**Re: Design Review Panel – Bungarribee Industrial Estate, Metcash Proposal**

**The Panel confirms it has met and reached consensus in regards to Project Description Report – Proposed Metcash NSW Distribution Centre and associated architectural plans prepared in June and July 2010.**

## DESIGN REVIEW PANEL – BUNGARRIBEE INDUSTRIAL ESTATE – METCASH PROPOSAL

PART 3A APPLICATION		TITLE WH1-A, B & C - FLOOR PLAN & ELEVATIONS	
METCASH LIMITED STATE DISTRIBUTION CENTRE		No.	1
BUNGARRIBEE INDUSTRIAL ESTATE HUNTINGWOOD SYDNEY		SCALE	1:100@A1
		DRAWN

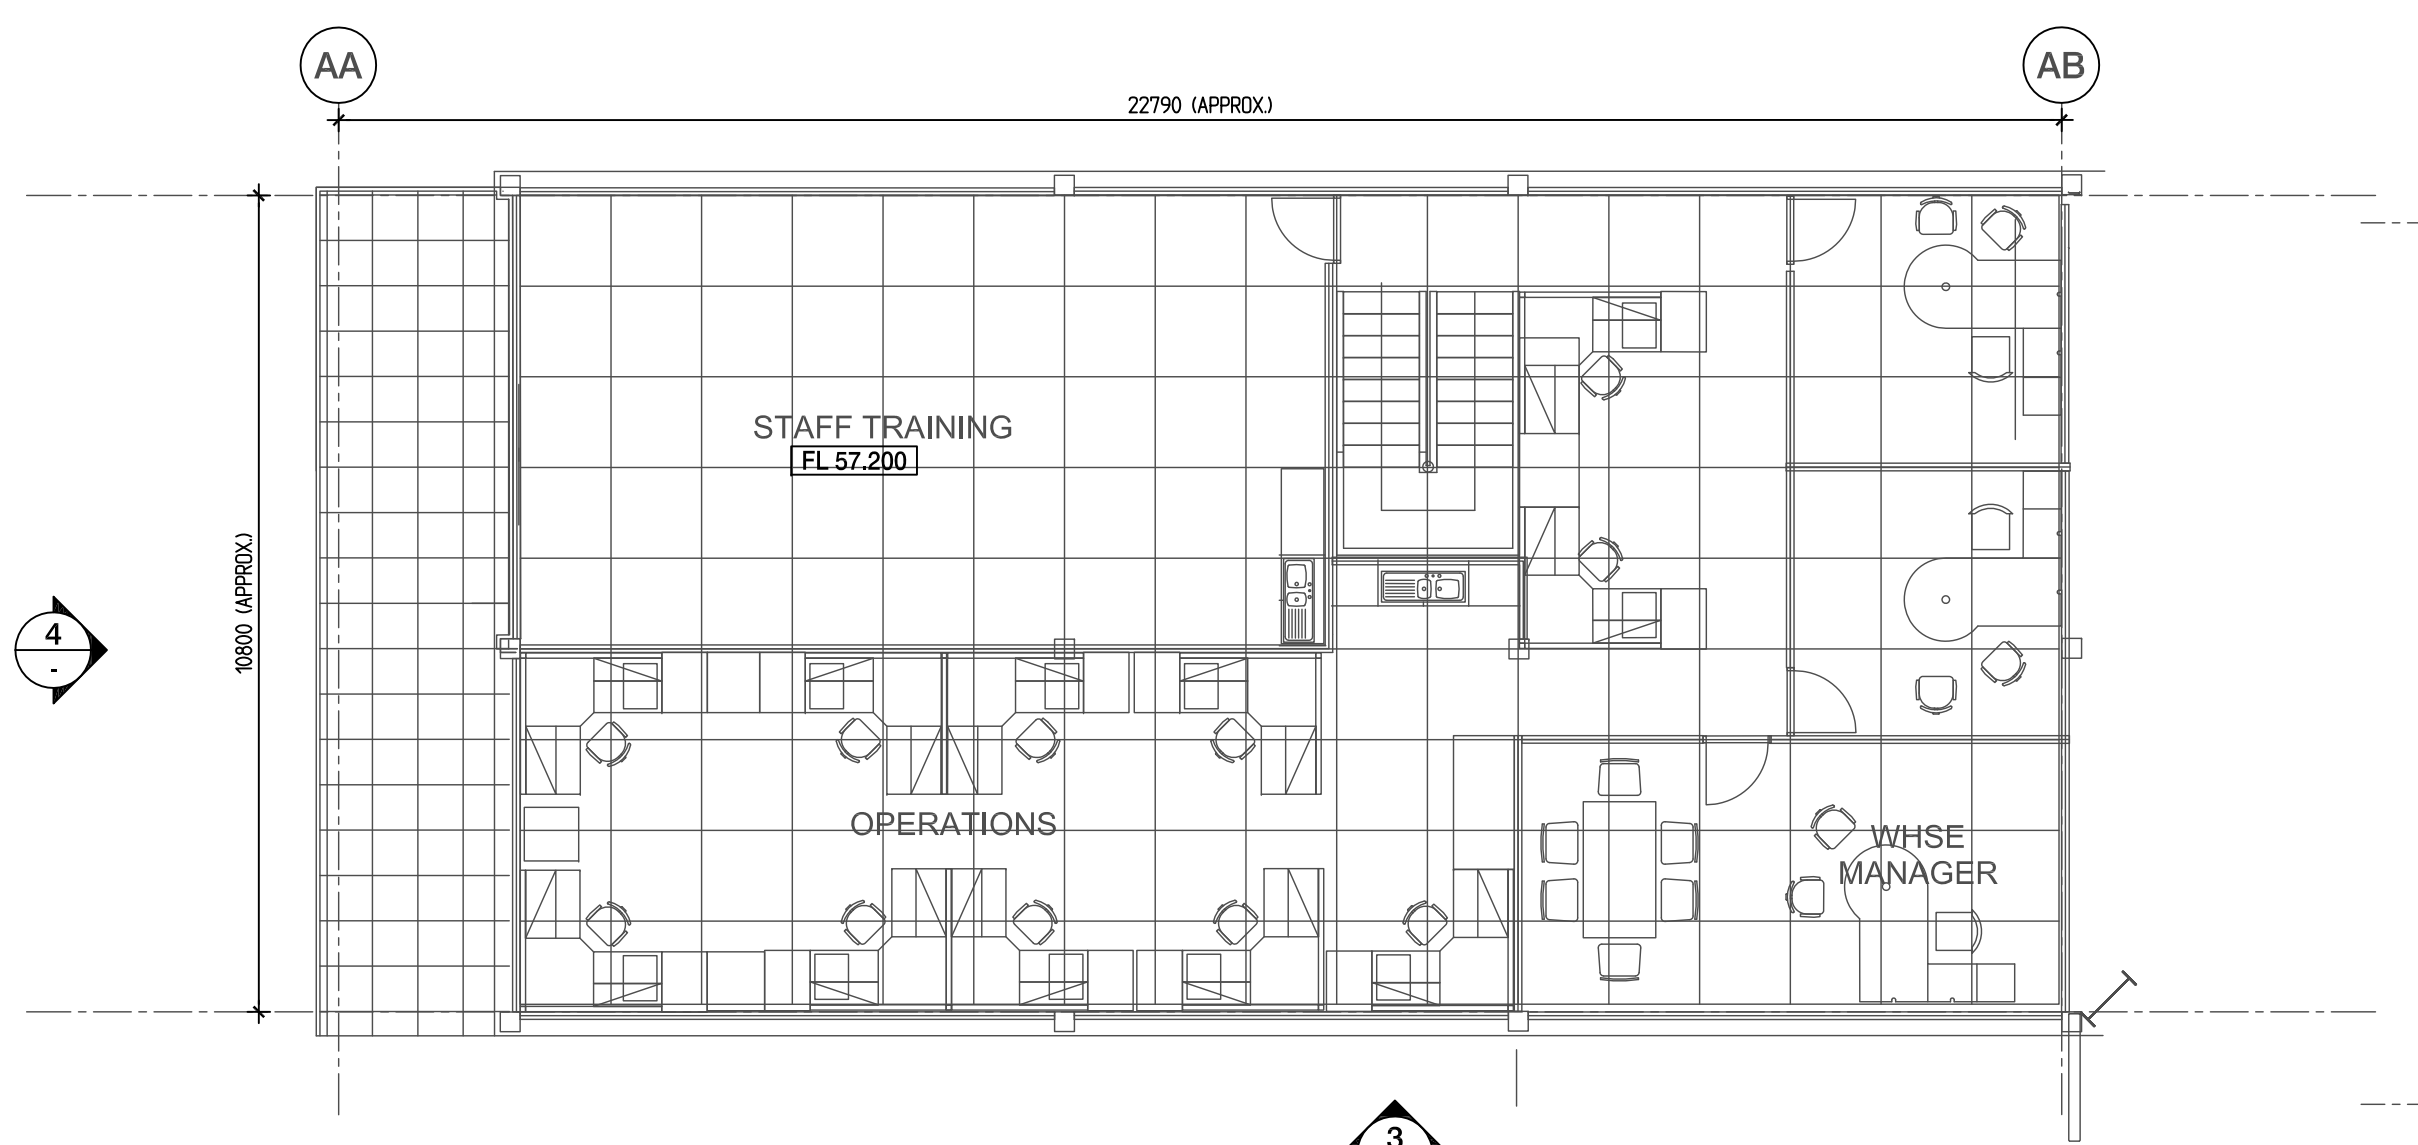
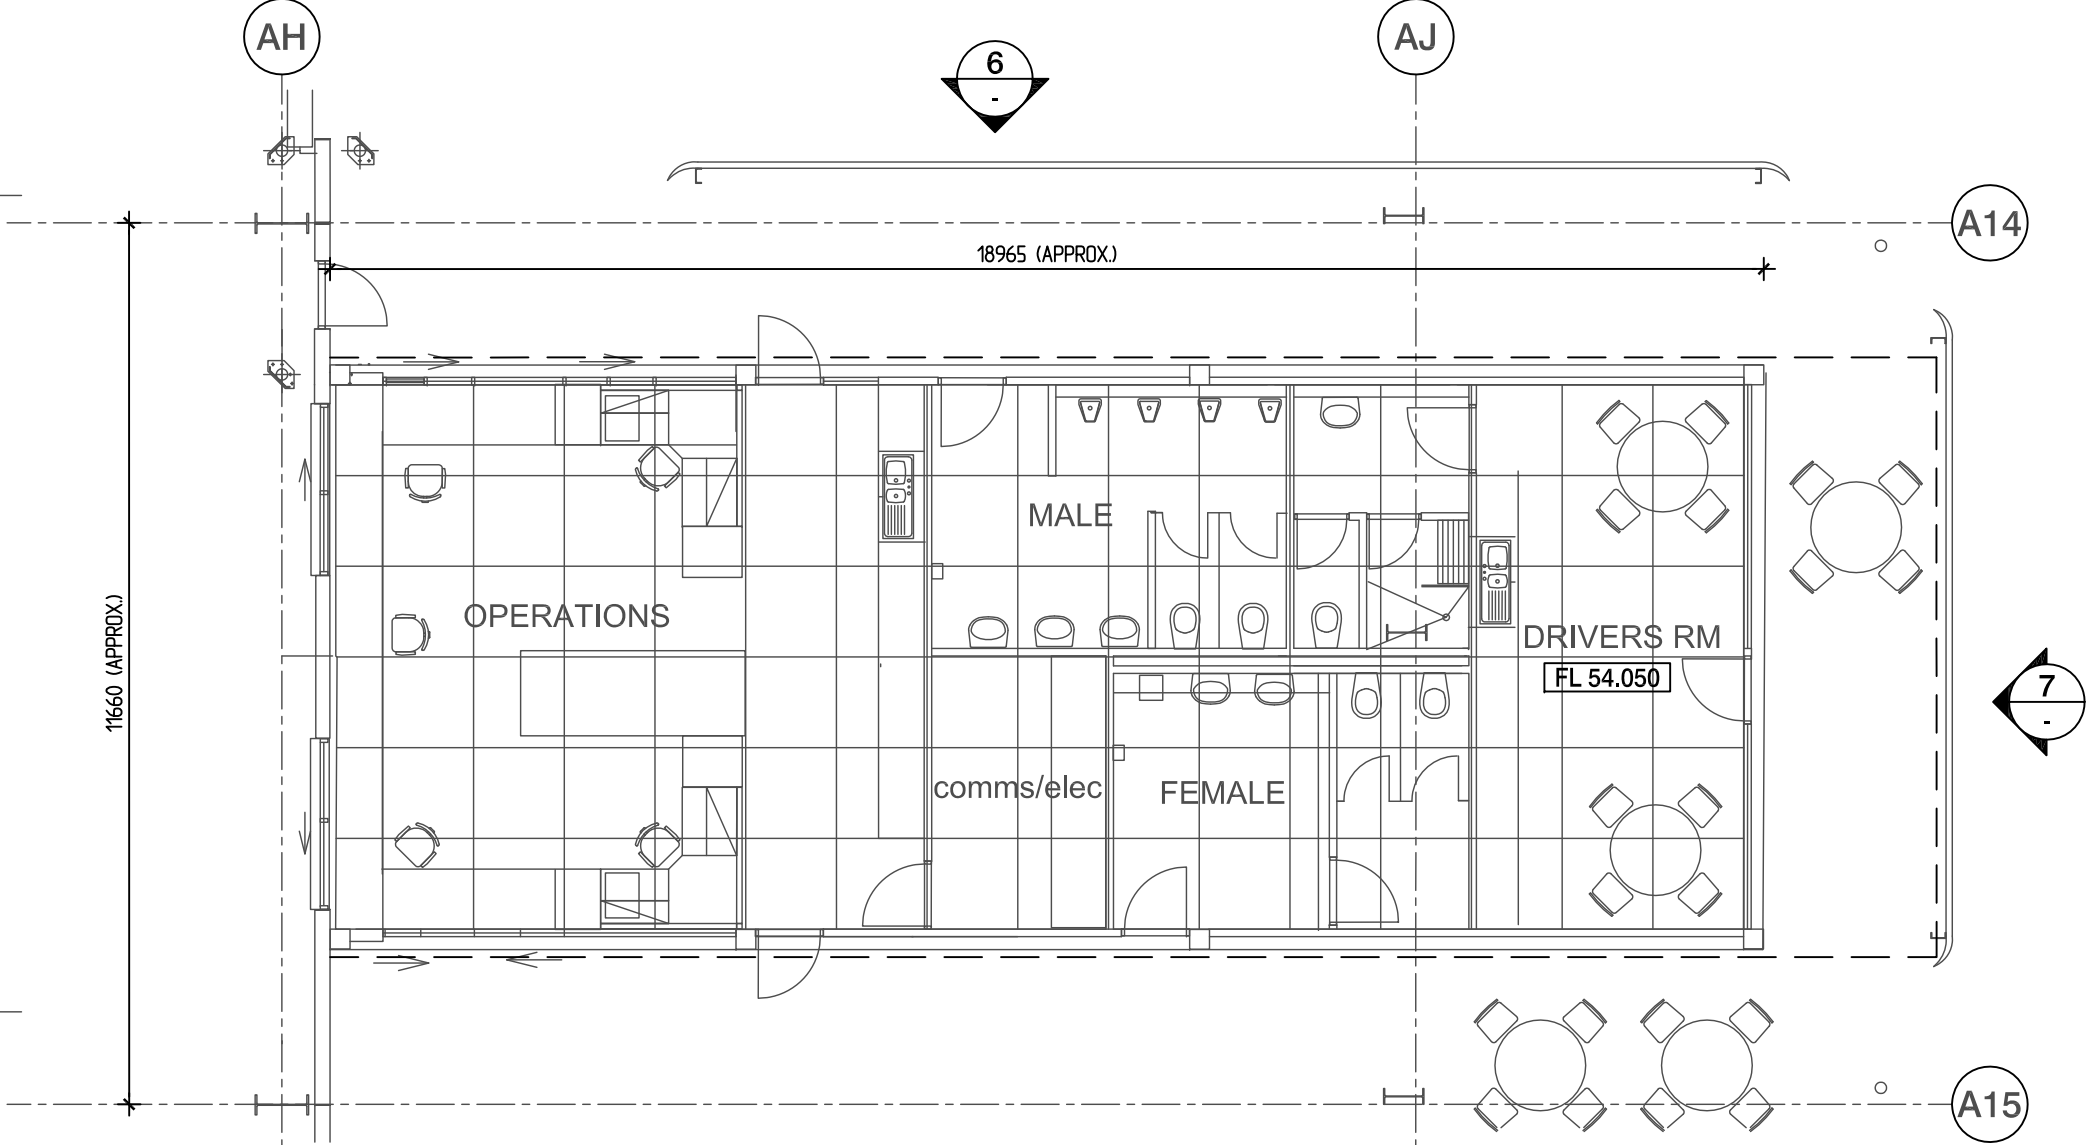
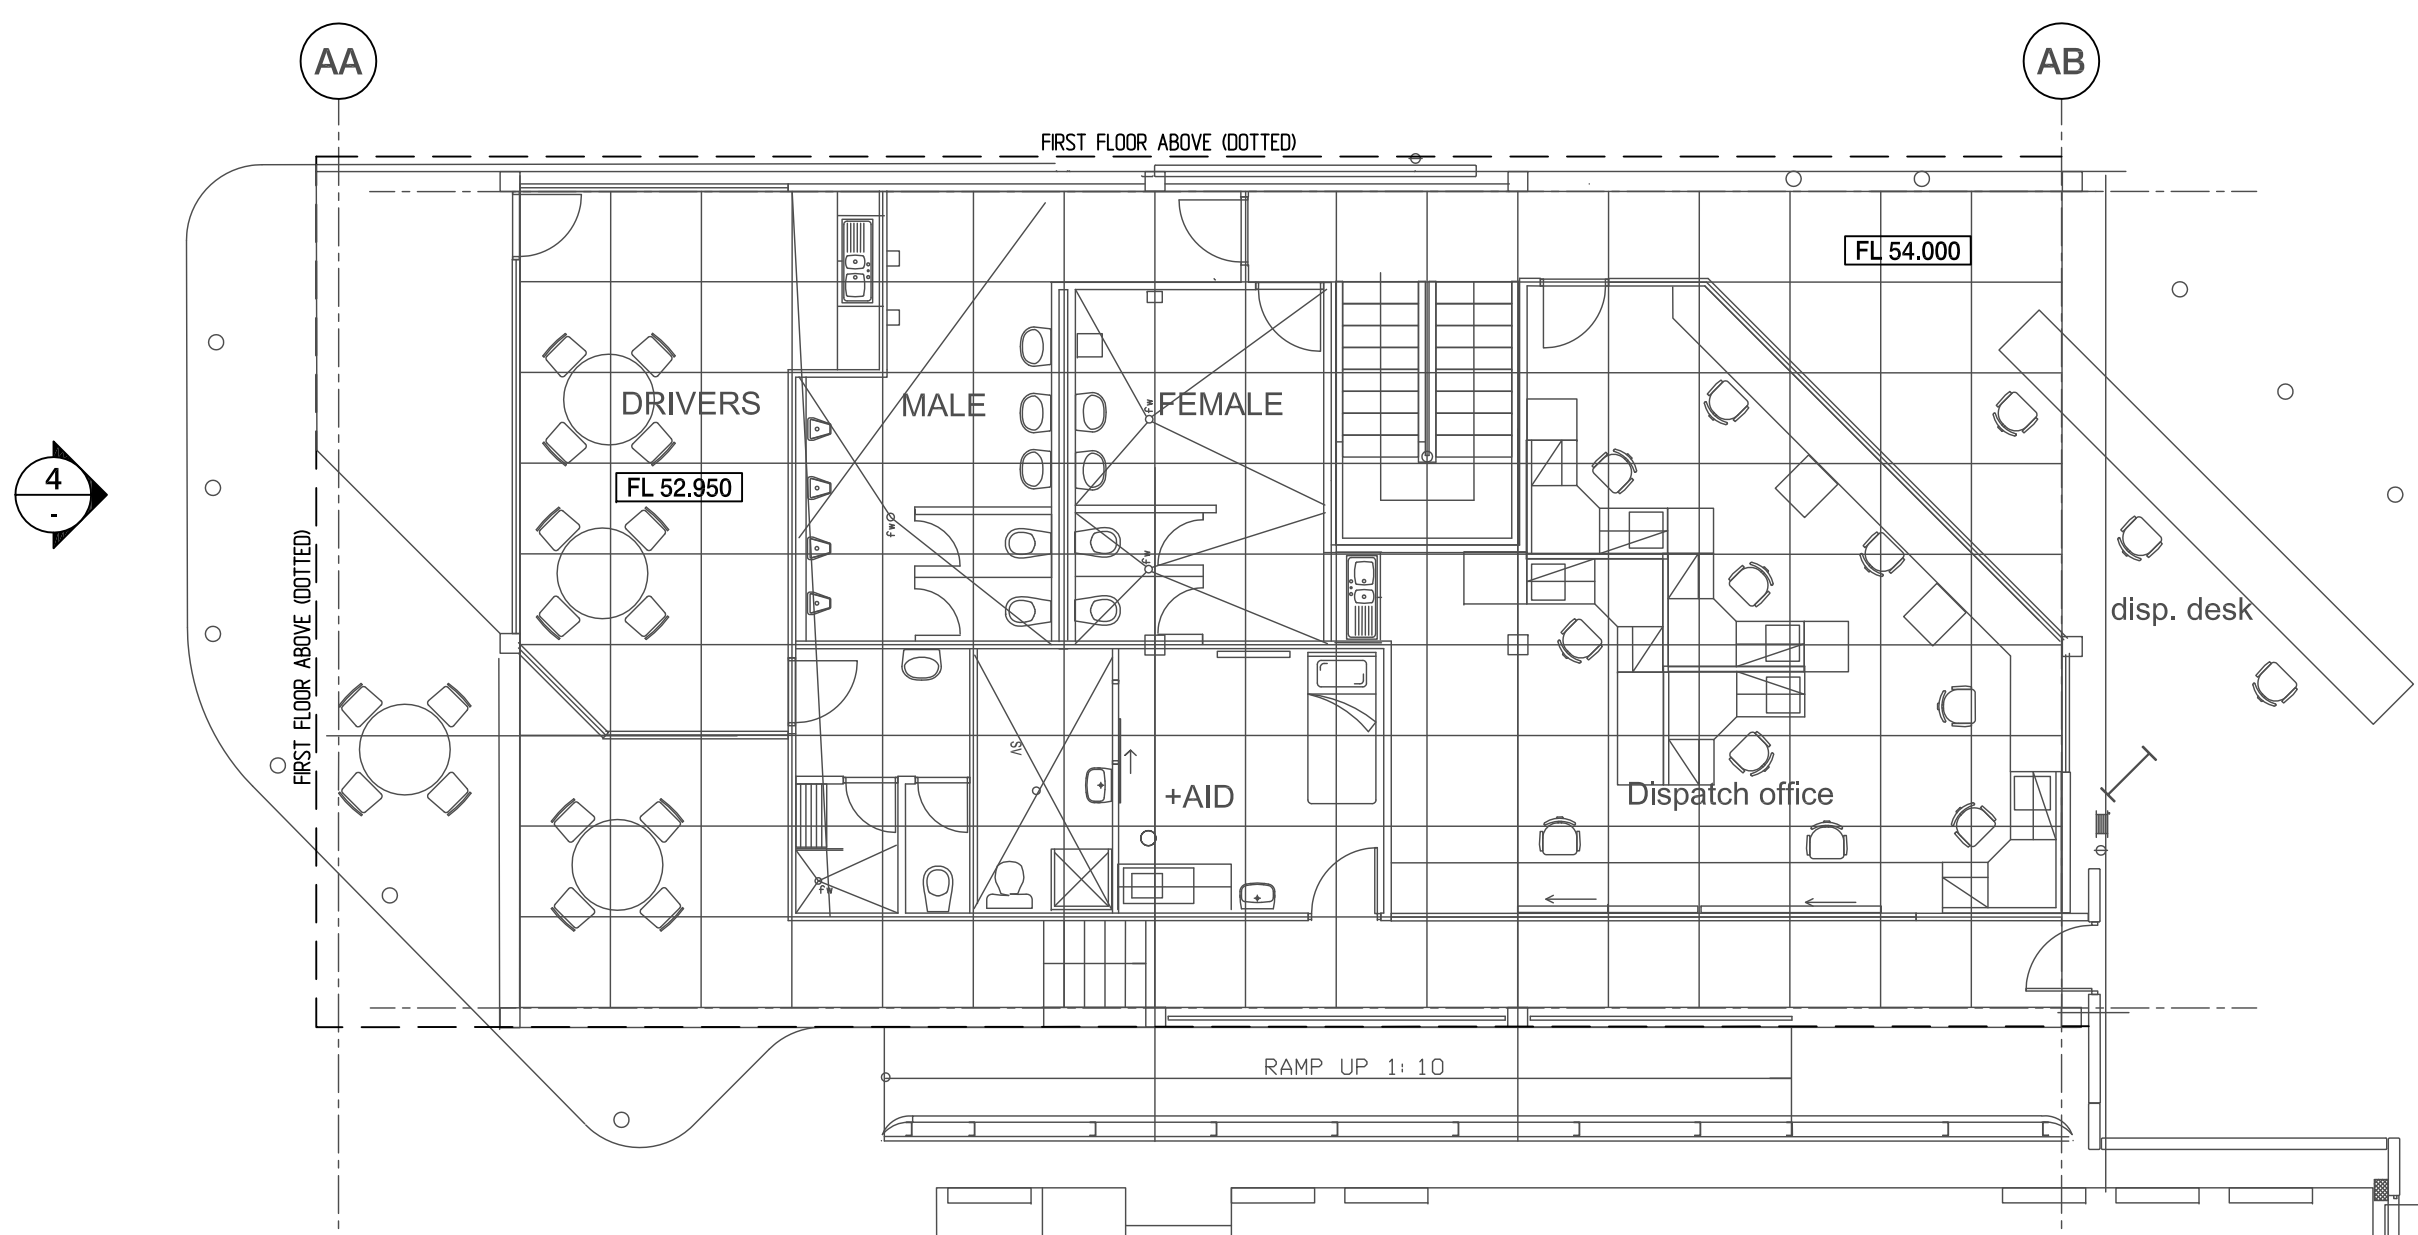
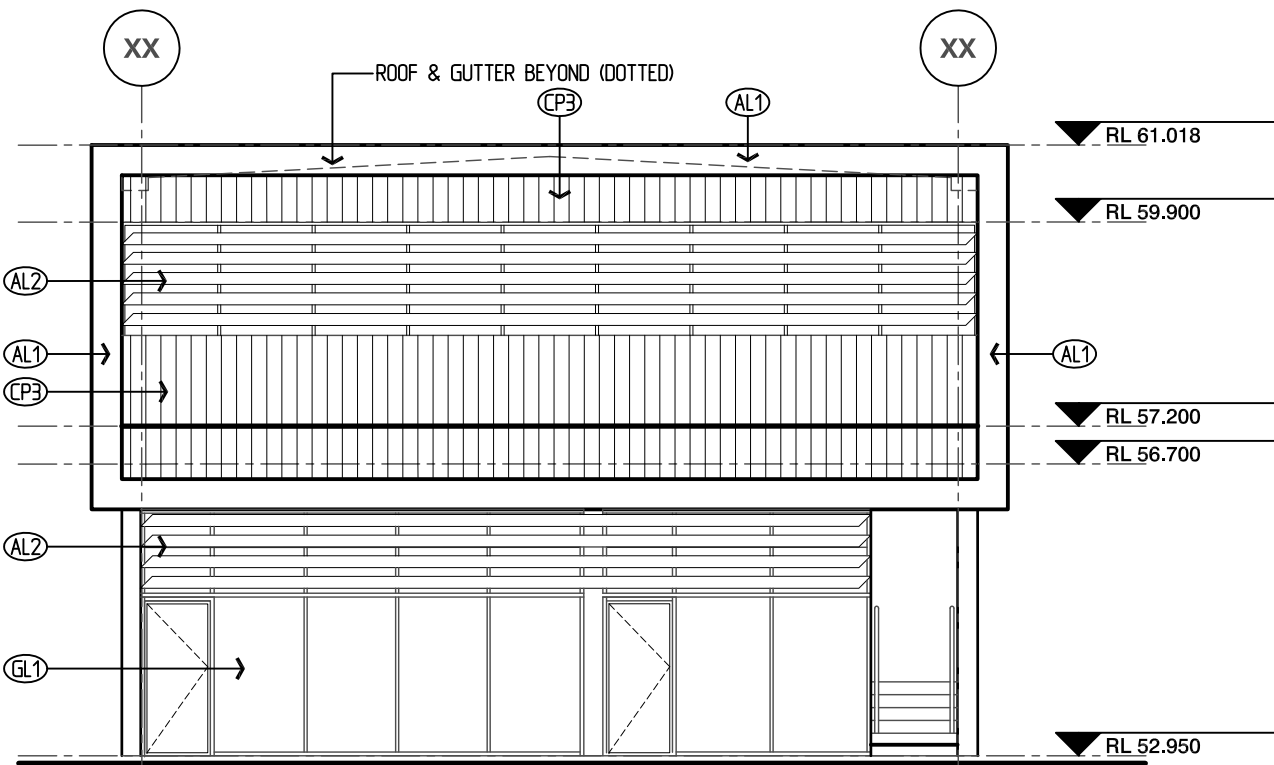
- The Panel considers that the Brabham Drive and Huntingwood Drive intersection is a major entry to the future estate. The Panel is concerned that the first built form seen as one enters the estate is the workshop/pump room/water tank that is back of house of the office area.

- The Panel would like to request Goodman to provide more architectural detail and plans as to this section of the Distribution Centre and if some design perspectives could be undertaken of this section from both Huntingwood Drive and Brabham Drive for the Panel's further review.

- It may well be necessary for Goodman to consider some design solutions to the above to assist in the visual quality of this component given its important gateway location and major entrance to the site and the Parklands.

- A final question the Panel has in regards to this component is clarification as to whether this is connected to the office area or is a separate building. The site plan shows it is connected whereas the aerial image shows it as a separate building.

<b>3. Office component and design</b>	
<ul style="list-style-type: none"> <li>The Panel complemented Goodman on the Office component design (which provides a visual break to the warehouse feel of the estate, provides an attractive street presentation to Huntingwood Drive and supports a high number of workers)</li> <li>The Panel questioned whether the office height and FSR was fixed and whether there was potential for future expansion</li> </ul>	<p>Staging plans show proposed office expansion</p>
<b>4. Workshop pump room/ water tank component and design</b>	
<ul style="list-style-type: none"> <li>Intersection of Brabham Drive/Huntingwood Drive is a major entry to the future estate and gateway to the Parklands. Therefore Panel is concerned that the first built form seen will be the workshop/pump room/water tank that is the back of house to the office area</li> <li>The Panel requests more architectural detail, plans and a design perspective of this area</li> <li>The Panel also requests confirmation on whether this area is connected to the office area or a separate building (the site plan shows it connected whereas the aerial image shows it separate)</li> </ul>	<p>The Design Team agrees the approach from the intersection at Brabham Drive and Huntingwood Drive to be of significant importance. Therefore the tank is to be screened with horizontal z-purlins on a steel support frame, this concept ties in with the louvered form of the proposed main office building. In due course the landscaped buffer zone will take form and partially screen the warehouse further.</p> <p>The Design Team considered cladding the corner with a screen of galvanised mesh, it was agreed this would be too industrial for a major entry.</p> <p>The Design Team considered cladding the corner with a screen of colorbond, it was agreed this would not provide relief form colorbond cladding each side of the tank. It was therefore decided to proceed with the horizontal z-purlins as represented on the Water Tank Sketch in Volume 2.</p> <p>The office building and the warehouse building are connected by the same concrete slab level and high level roof lights, refer to Drawing No. BIE-3A-A19 revision 2 in Volume 2.</p>
